City of Portland, Maine - Building or Use Permit Application
 389 Congress Street, 04101 Tel: (207) 874-8703, Fax: (207) 874-8716

Permit No: 09-0190	Issue Date:	CBL: 425 A002001
------------------------------	--------------------	----------------------------

Past Use: Commercial - Offices Spurwink	Proposed Use: Commercial - Offices Spurwink Amend permit #090144 to add a stairway to 2nd floor and 5 offices above existing offices.	Permit Fee: \$410.00	Cost of Work: \$39,000.00	CEO District: 4
Proposed Project Description: Amend permit #090144 to add a stairway to 2nd floor and 5 offices above existing offices.		FIRE DEPT: <input type="checkbox"/> Approved <input type="checkbox"/> Denied	INSPECTION: Use Group: Type	
		Signature:	Signature:	
PEDESTRIAN ACTIVITIES DISTRICT (P.A.D.)				
Action <input type="checkbox"/> Approved <input type="checkbox"/> Approved w/Condition <input type="checkbox"/> Denied				
Signature: Date:

MEZZANINE FRAMING PLAN

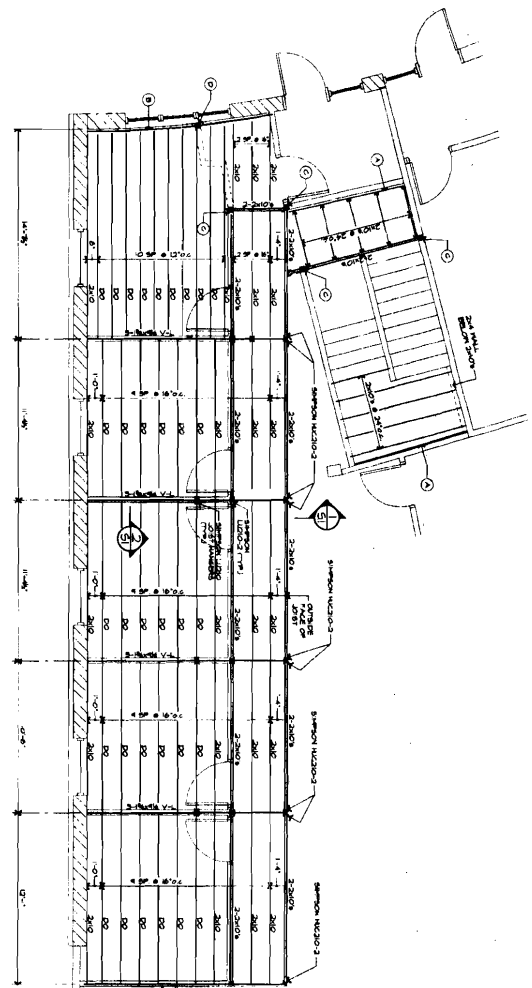
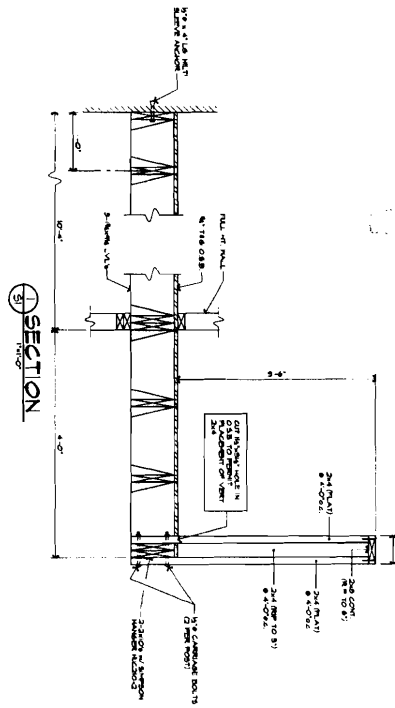
3/16/2009-jmb: Spoke to Earle R. About viewing this as a 2nd floor not a mezzanine due to it exceeding the square foot allowance. Per Sec. 503 2 stories are allowed. Sec. 1018 for number of egress allows exception under 1014.1 and Sec. 1019 allows the exit stair to not be enclosed as OL is under 10. They will be adding windows to the 2nd floor office spaces. Also, asked about cost...he did put 39K on application so he will pay the difference.
